Project: Haybrook Short Plat  
Permit#: SP-22-00002  
Date: 02/24/2022

RE: SP-22-00002 Haybrook Land Holdings

SUBJECT: Haybrook Land Holdings SP-22-00002

SP-94-26

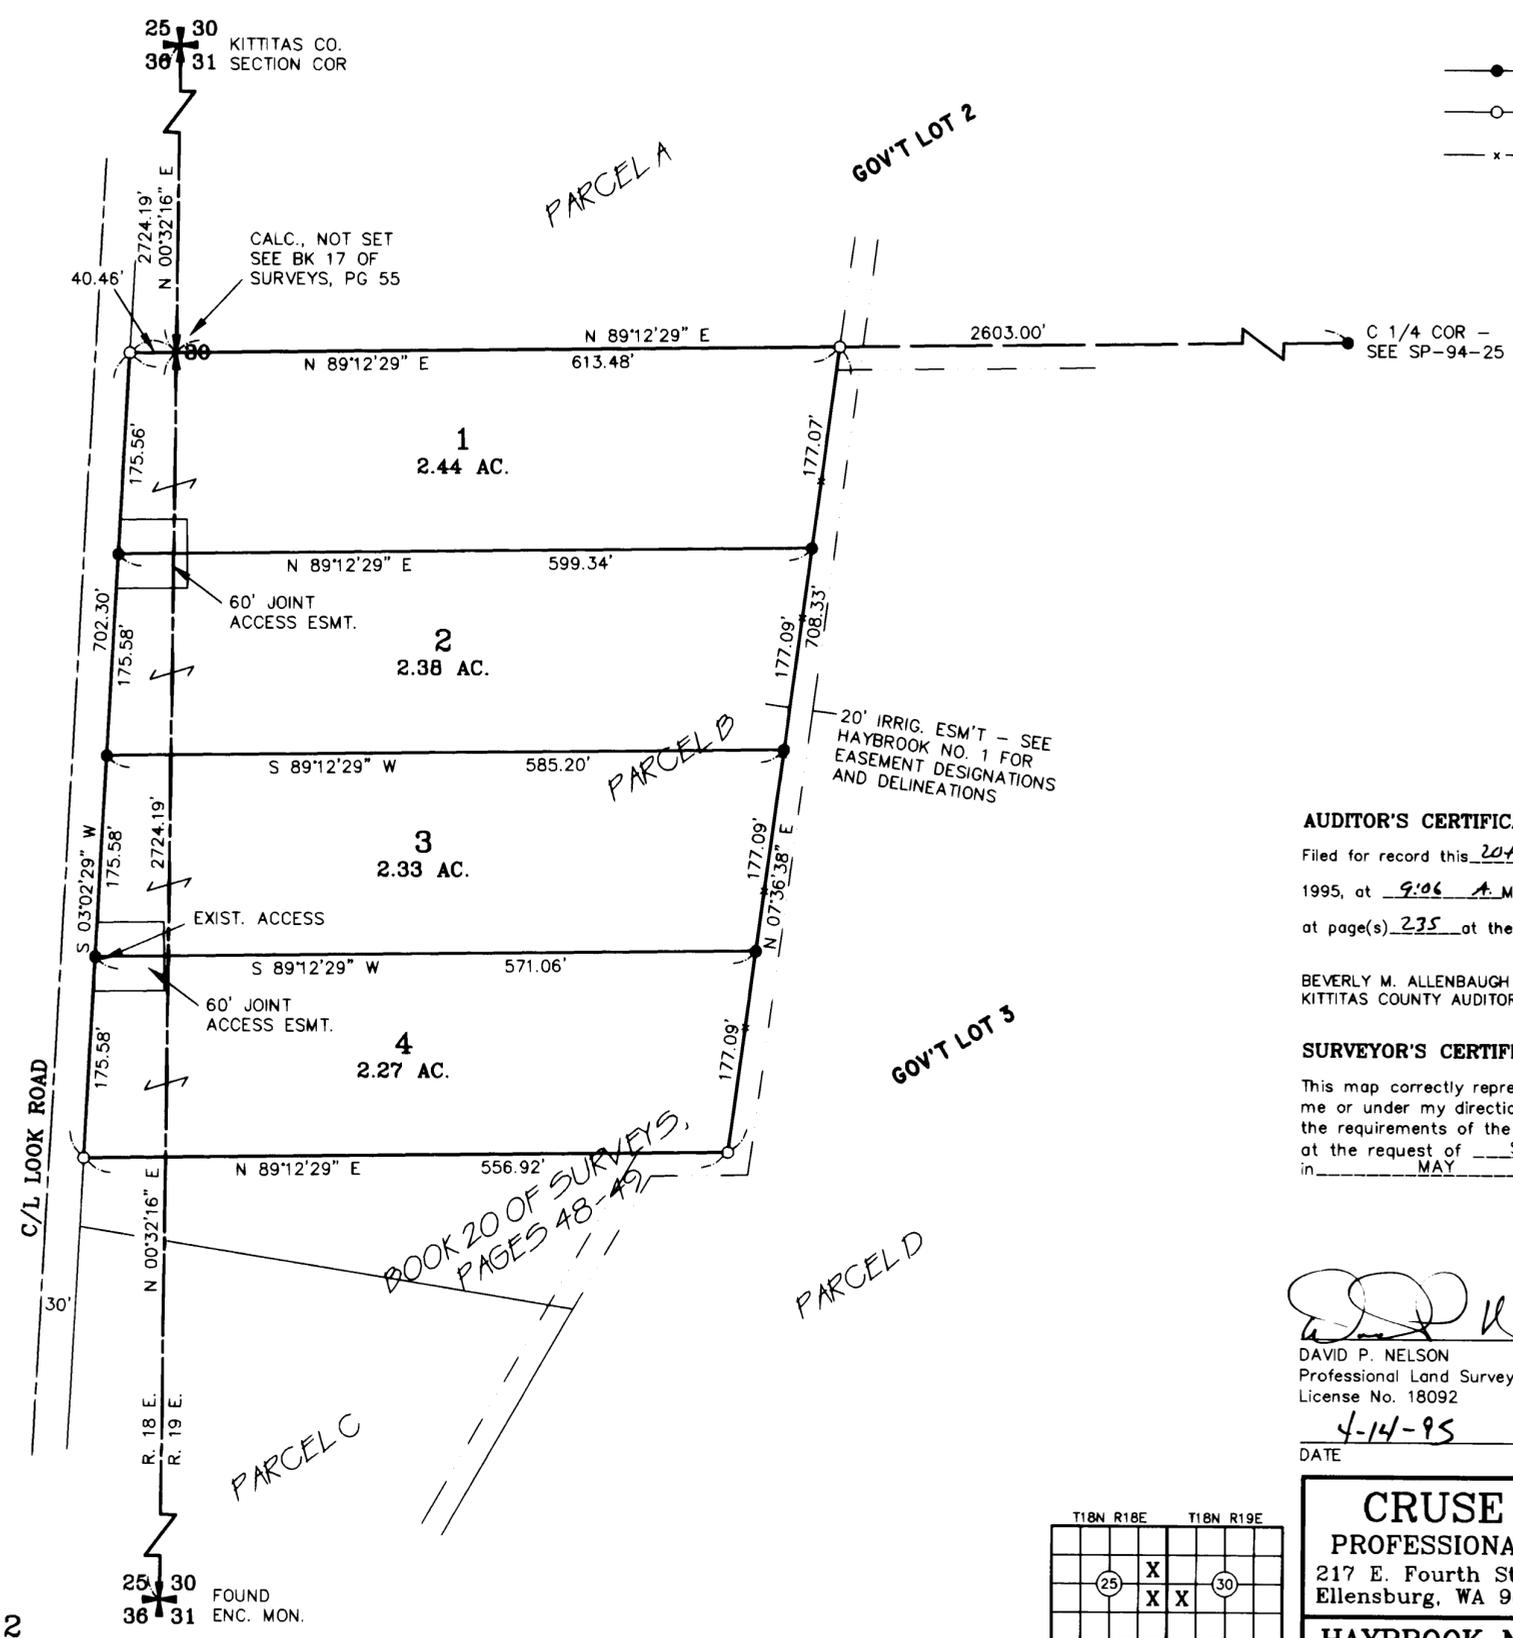
1. All access easements shall be shown on the face of the plat. A 60' Joint Access Easement serving lots 3 & 4 is shown on the Haybrook No. 2 SP-94-26. This easement is not referenced or shown on the preliminary short plat submittal.
2. A recorded easement with a minimum width of 30' is required to serve all four lots. The 30' joint use driveway detailed on the preliminary submittal is not described as an easement. Please provide an easement for this access.

HAYBROOK FARMS - PHASE 1
 PART OF GOV'T LOT 3, SECTION 30, T. 18 N., R. 19 E., W.M.
 AND OF THE E 1/2 OF SECTION 25, T. 18 N., R. 18 E., W.M.
 KITTITAS COUNTY, WASHINGTON

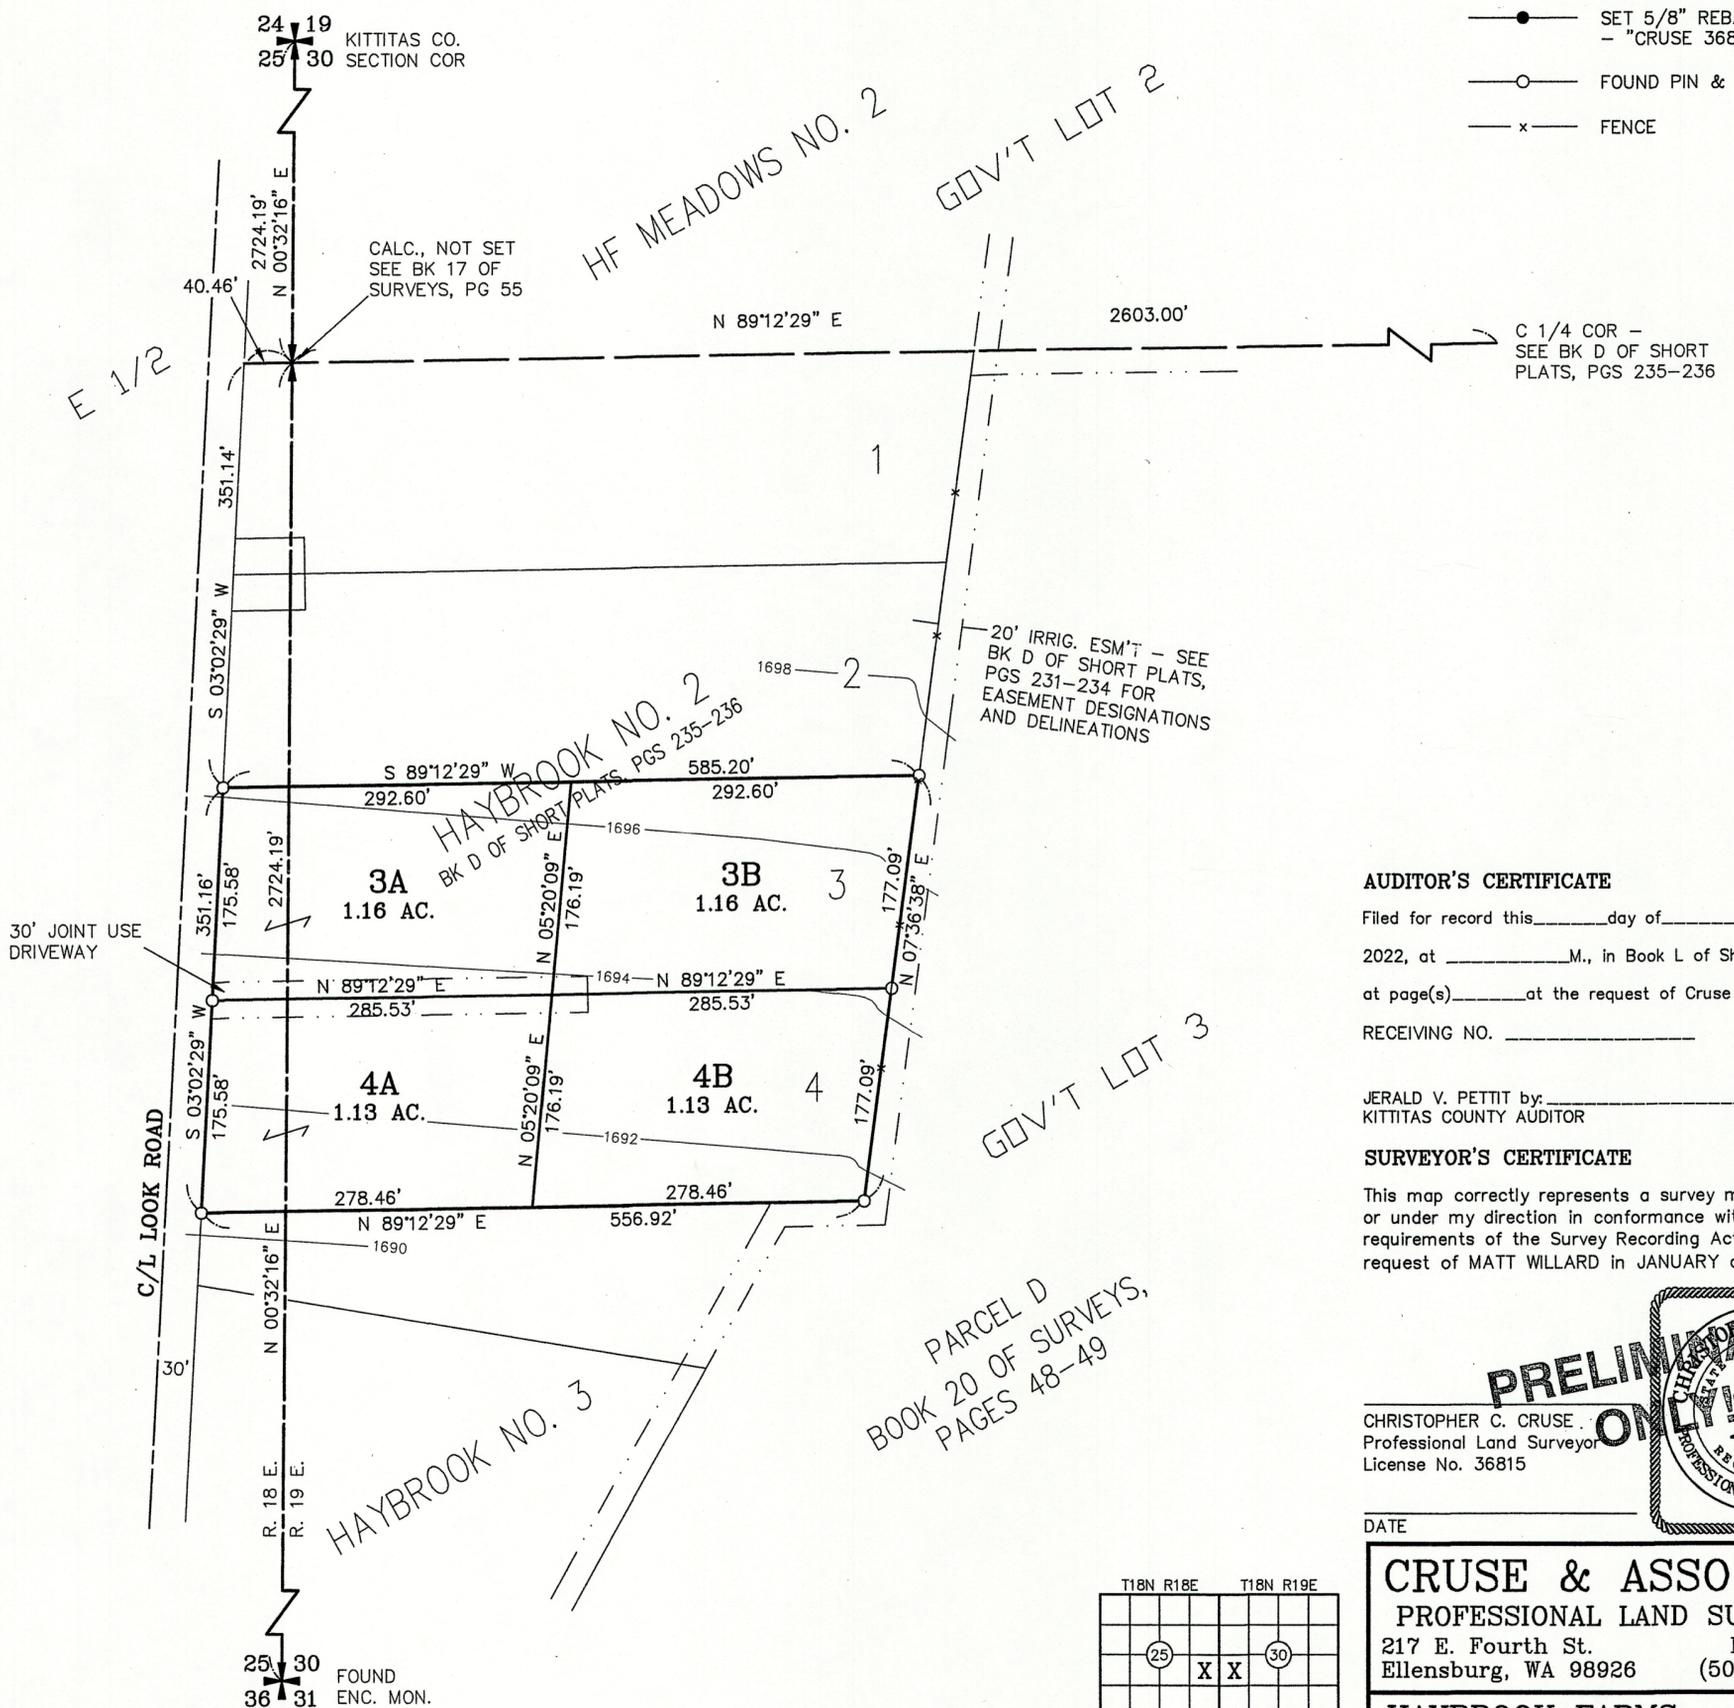
1. Lot Closure Sheet is missing
2. Title Report needs to be submitted
3. Purpose of Survey was not identified nor was the application number on the survey (KCC 16.10.020(1))
4. Basis of Bearing was not identified on the map nor was it in the notes (WAC:332-130-050(1)(b)(iii))
5. Roadway ownership, ROW and surfacing should be on the map.

6. If elevations or contours are to be shown, then the map must meet Topo Standards per WAC:332-130-145.
7. All property corners shall be set in the field and shown upon the face of the map.

1. Lot line label in joint use driveway may become unclear due to crossing linework.
2. Please identify if the 40' joint use driveway is existing or herein created.
